Marine Management Organisation

Your Reference: EN010081
**Our Planning Inspectorate
Reference:** EGGB-SP011
Our Internal Reference:
DCO/2016/00006

26 October 2017

RE: EGGBOROUGH CCGT – SECTION 89 AND THE INFRASTRUCTURE PLANNING (EXAMINATION RPROCEDURE) RULES 2010: EXAMINING AUTHORITY’S “RULE 8 LETTER”

INDICATIVE COFFERDAM ARRANGEMENT
(COOLING WATER DISCHARGE POINT)

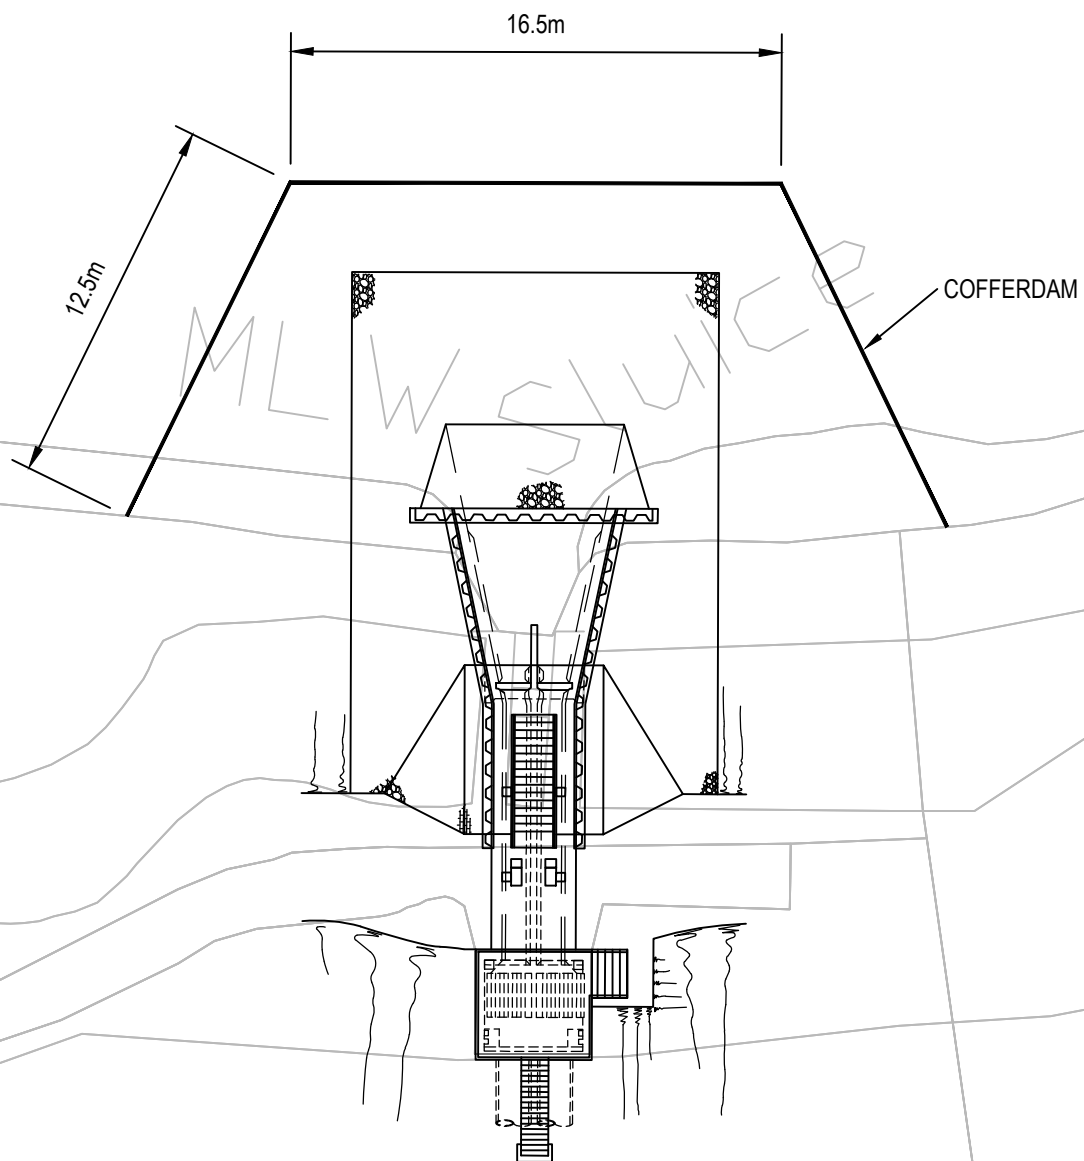
3.8 Regarding the removal of the Cofferdam required for the construction of the Outfall, as the MMO have been informed that the firm details of construction are not currently available and as such, have not been provided in support of the application, the MMO has requested the following condition:

Such a condition will enable to the MMO to review and where required consult upon the exact details of construction which will include the use of a cofferdam to provide a dry and safe working area for contractors. The MMO re-state the comments made in our Section 56 response dated 09 August 2017 (item **1.3.2**) which reiterate that 'any cofferdam to be placed below mean high water springs should be included as part of the method statement supporting the DML'.

'The licence holder must submit a method statement to the MMO at least 6 weeks prior to the proposed commencement of the licensed activities. (2) The licensed activities must not commence until written approval is provided by the MMO'.
